BRIGHT PLAN CIVILS

Drainage Officer
Arun District Council
Application No. Y/57/21/PL

RE: SUNNYMEAD FARM, NORTH END ROAD, YAPTON BN18 0DL

Consultant Response to Engineers Comments Regarding Surface Water Drainage (in Red)

DRAWING Site Plan EXISTING	SCALE 1:100 @A1
DATE September 2020	DRAWN MH
DRAWING NUMBER 20148-02	REVISION B

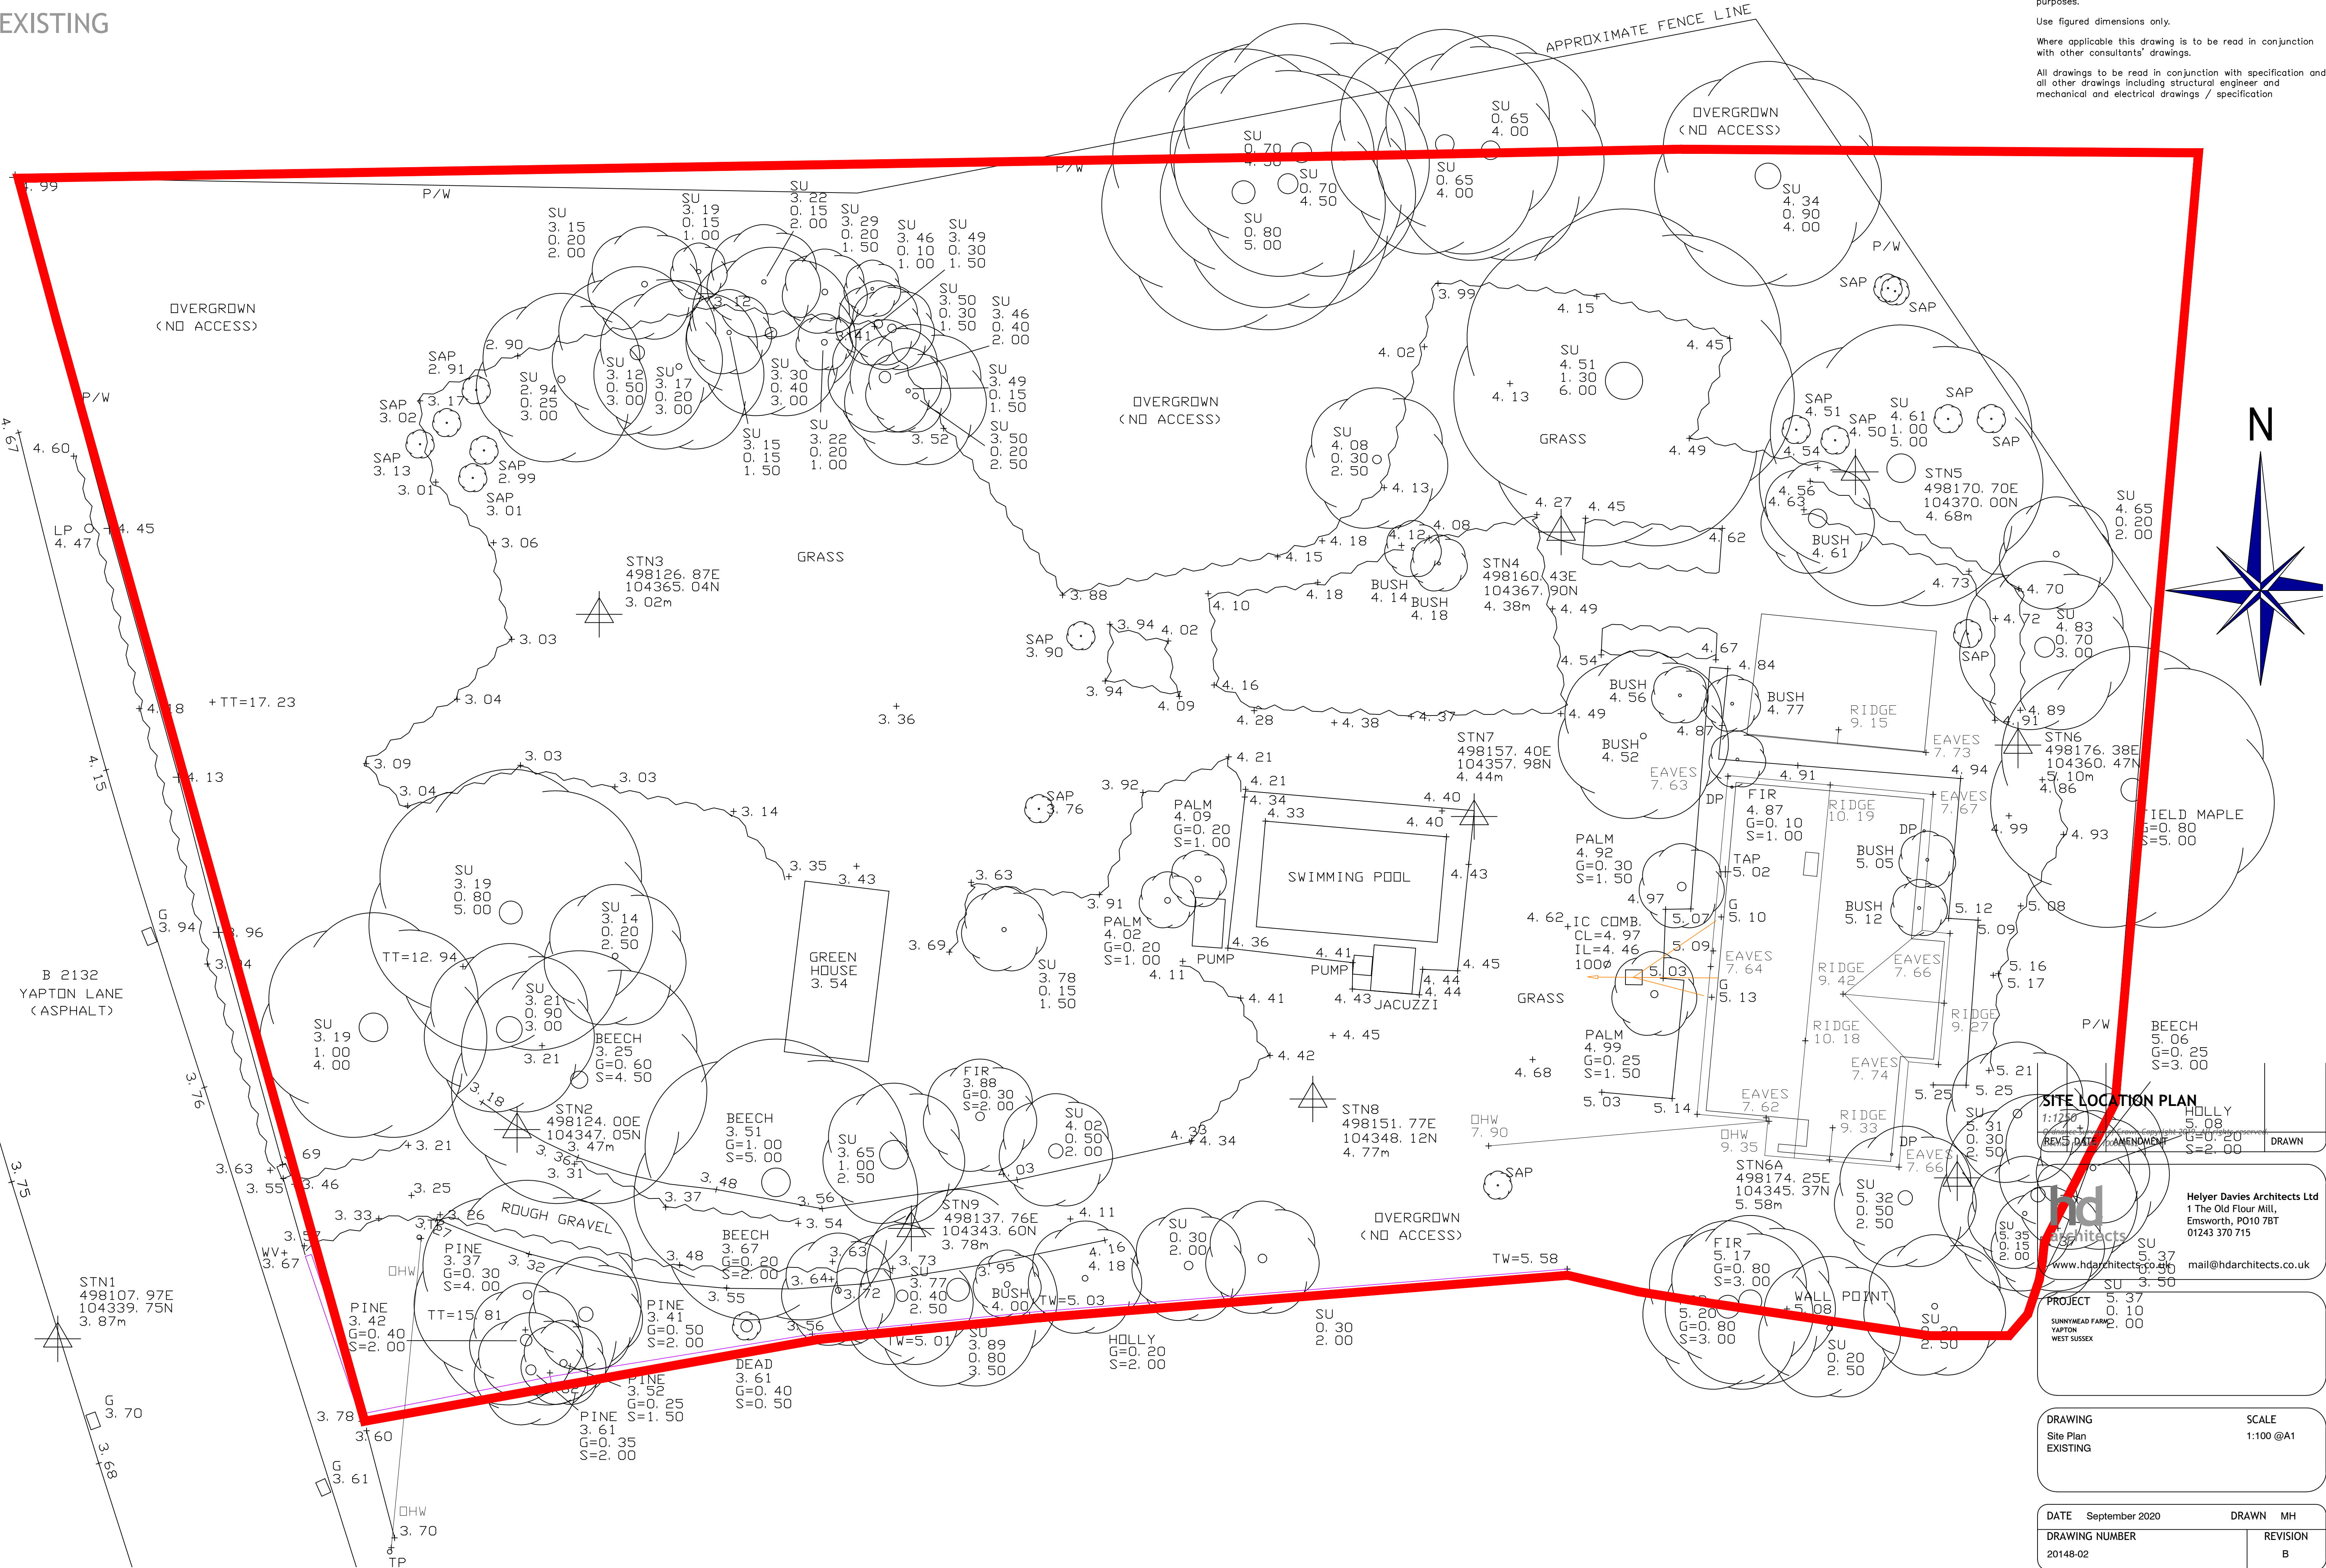
1. There is a large low area to the north west of the site, this is shown as an area of surface water flooding in a 1 in 30 event and greater on our mapping and is further evidenced in the topographical survey. Flood depths for the 1 in 100 event for a large area are 0.6-0.9m, with one small area reaching a depth of 1.2m. The three detached properties are proposed to be built in this area. The Drainage Strategy Report propose to protect the properties from flooding by raising ground levels at the north and west of the site. The applicant proposes to provide flood storage volume (for the displaced storage) in the centre of the site which will extend into the parking area and rear gardens of the detached properties. Within the basic calculations that are provided they have allowed for a flood depth of 450mm in this area, based upon predicted flood depths it is our opinion this is insufficient.

The applicant argues that surface water from outside the site is not being drained to this low point, we dispute this, the area is a low lying point for the surrounding area (as shown on the LIDAR mapping attached), and as such we expect that surface water from the surrounding area will drain here in high rainfall events. **If the equivalent volume of storage is not provided on site then this will likely increase flood risk elsewhere.** The Drainage Strategy Report does not provide adequate evidence that they have provided enough storage. Furthermore, allowing the parking area and rear gardens to flood to up to 0.45m is not safe or sustainable development.

Thank you for your detailed comments, we acknowledge that there is a 'low point' within the site and this is clearly visible on the LiDAR mapping. It is worth noting that the LiDAR mapping is supplied with an advisory regarding accuracy and this is due to the relatively coarse grid that this method of measurement uses. It also shows the surrounding topography to be fairly flat. The applicant has commissioned a detailed topographic survey which provides a significantly more accurate measurement of the levels on and around the site.

A review of the local FEH catchments for this area shows that there are two defined local catchment areas here (also based on LiDAR). This shows that the potential catchment that 'could' drain to the low point on the site lies in between these two areas.

There are urbanised areas either side being 'West Bank' and 'North End' which would compound run-off (structures, fences, walls, etc) or be drained to local private systems. This leaves the West Sussex County Council highway corridor as the potential source in respect of run-off. However, there are numerous highway gullies at the low point directly adjacent our site which would collect this run-off, Arun District Council's asset mapping indicates a drain (possibly owned by West Sussex County Council) on the western boundary discharging to the watercourse to the north of the railway line. Highway drainage improvements which could include additional road and edge of carriageway water stops could assist in controlling this (3rd party run-off) from potential overspilling to the site. Clearly a drainage investigation will be necessary.

DRAWING	SCALE
Site Plan	1:100 @A1

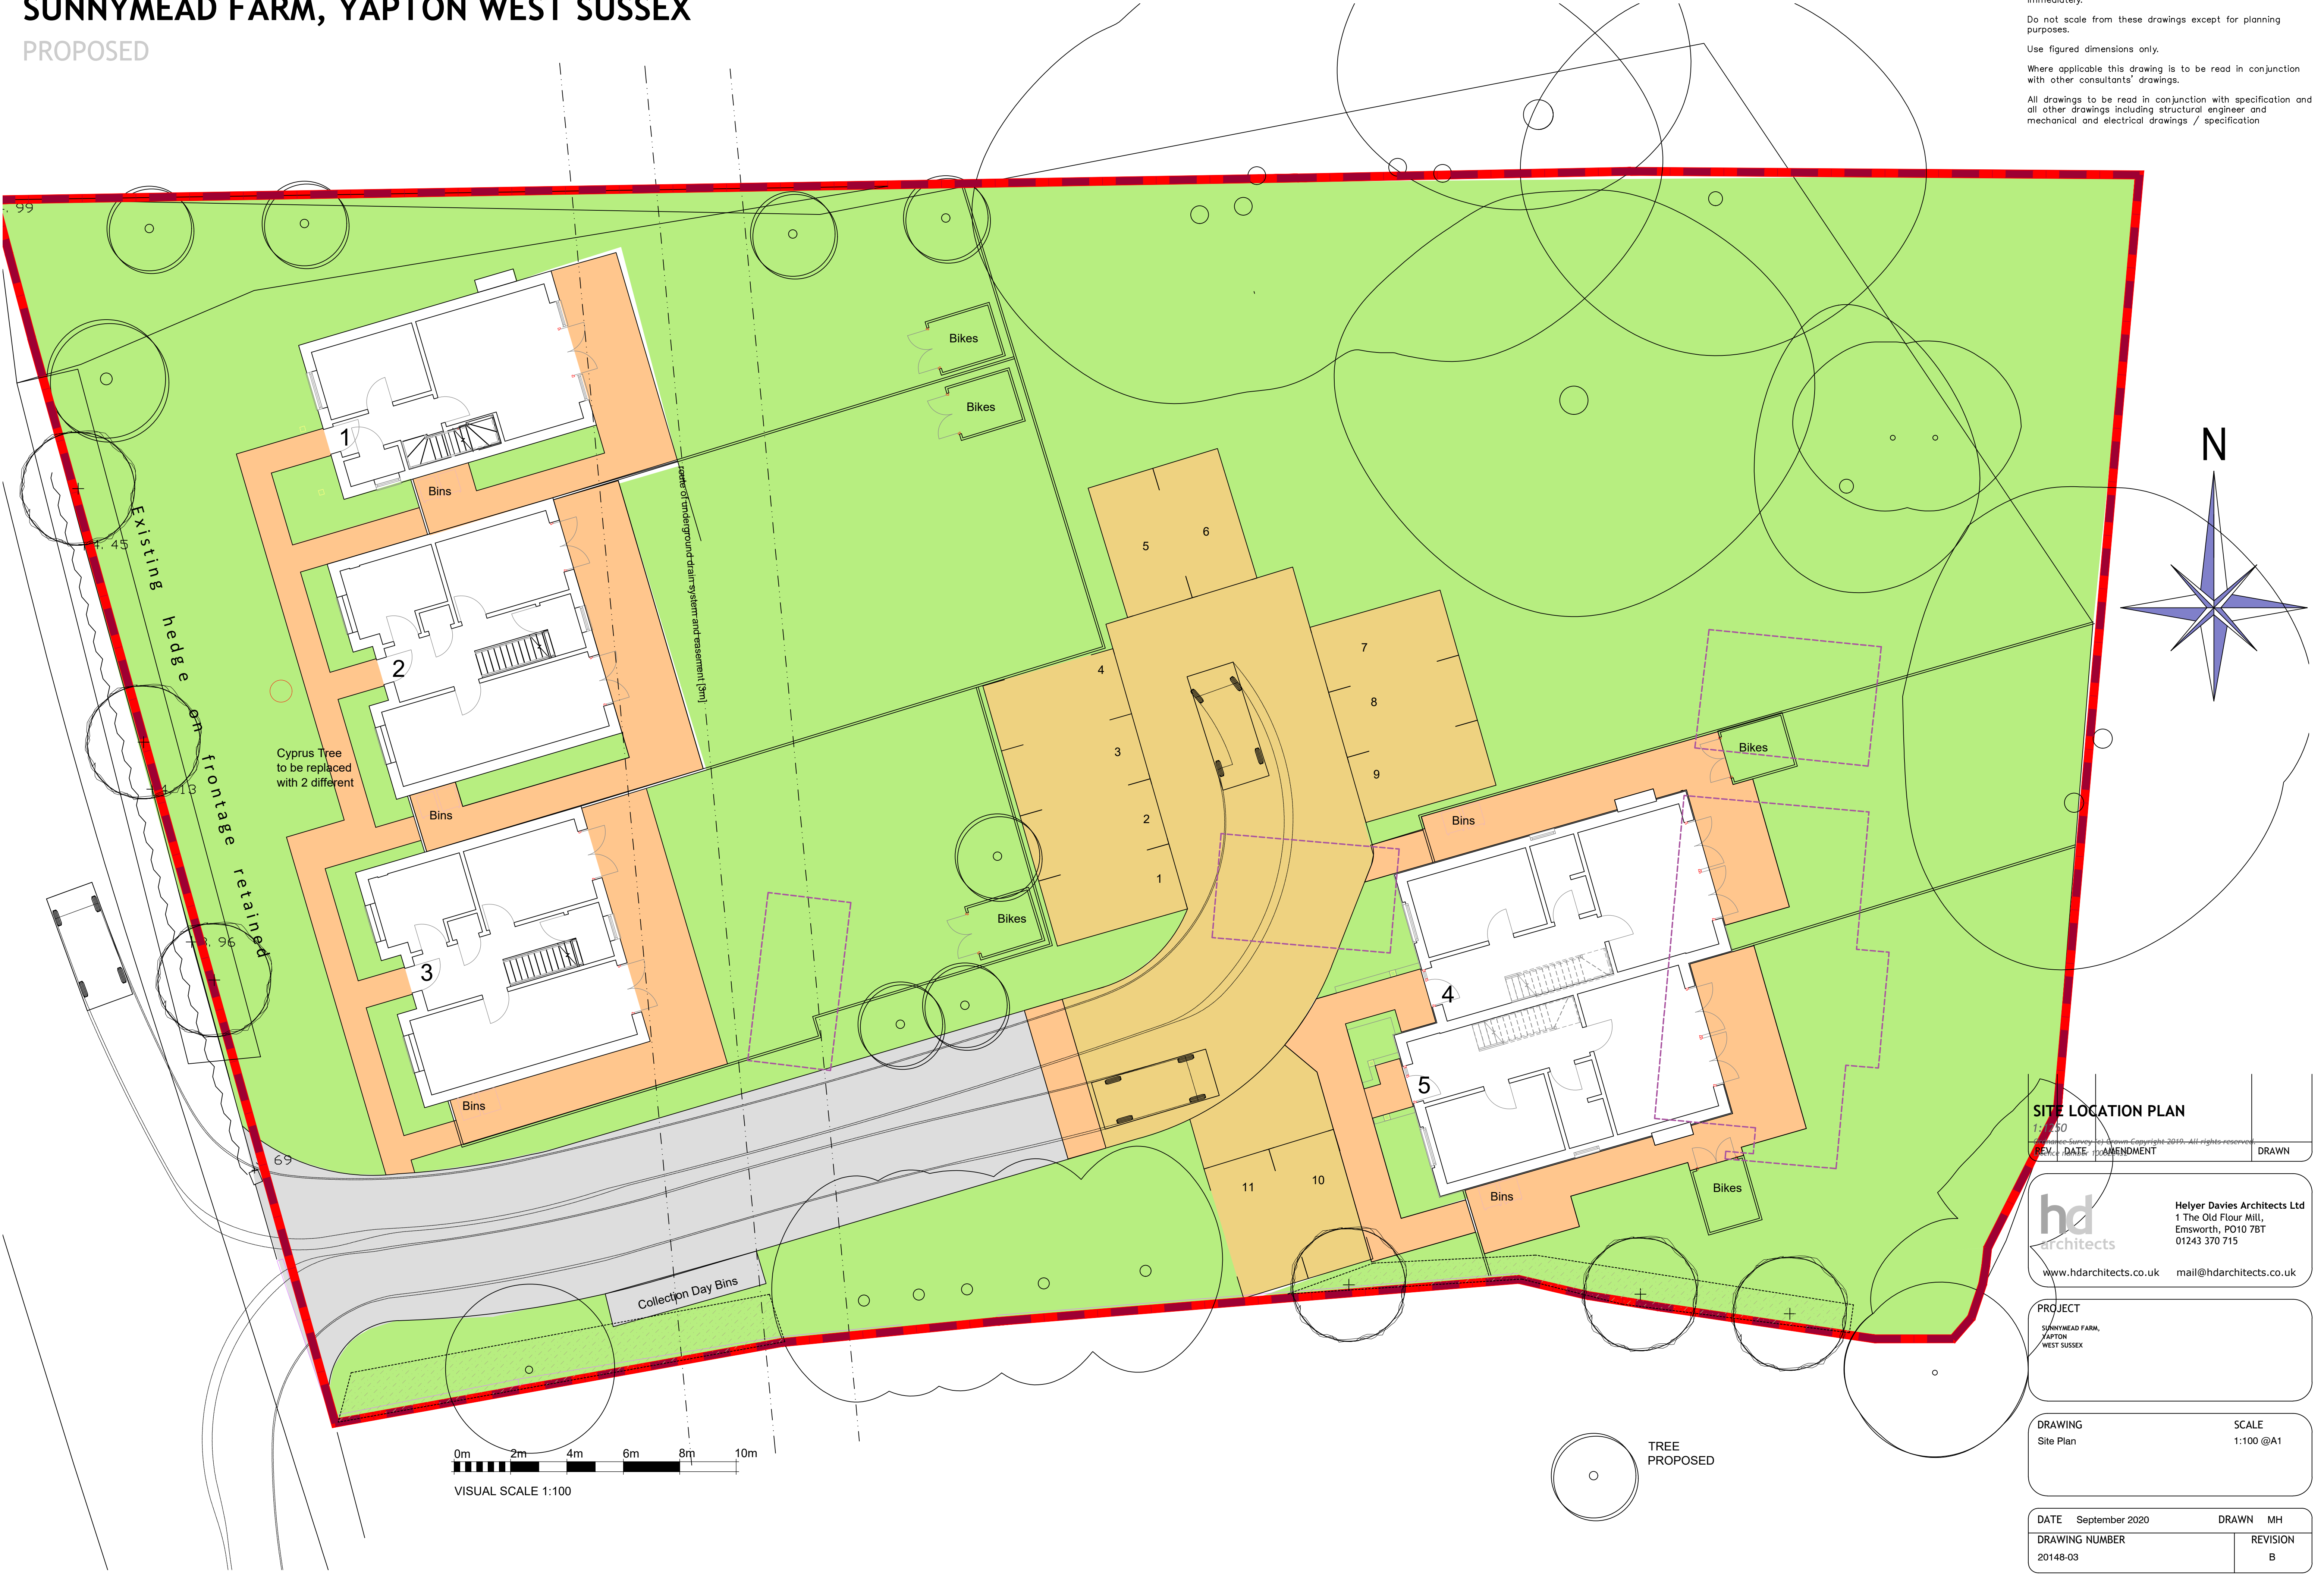
The proposed finished floor levels are too low. These should be set at least 300mm above the flood depth for the 1 in 100 year +40% event. When flood extents and depths for the 1 in 100 year plus 40% cc event are not available it is standard practice to utilise the 1 in 1000 year event. The 1 in 1000 year event, flood elevation appears to be somewhere between 4 to 4.5m AOD, a reasonable assumed level would be 4.25m AOD. Therefore finished floor levels should be 300mm above 4.25m AOD.

Noting the low point with the 'indication' risk of surface water flooding, there are 3 No. dwellings potentially at risk fronting North End Road. Clearly these dwellings need to tie-in with the Public Highway surface for accessibility and as such can be stepped to match the Highway corridor elevation which rises to meet the level crossing. We agree there is scope to raise these slightly.

The remaining 2 No. dwellings to the rear are wholly in FZ1 and low risk so will remain unchanged.

The 3 No. dwellings sit within the existing low point so we have proposed this shall be shifted further east to maintain an equivalent area in terms of level. In doing this we can also comply with demonstrating control of exceedance run-off around new dwellings. It is evident there is further opportunity here to maximise the 'above ground' storage provision within the shared parking and landscaped areas, and so whilst this is already covered in our report, we have refined the proposed levels. The Conceptual Drainage Strategy drawing has been updated/enhanced to reflect a number of the points discussed in this response.
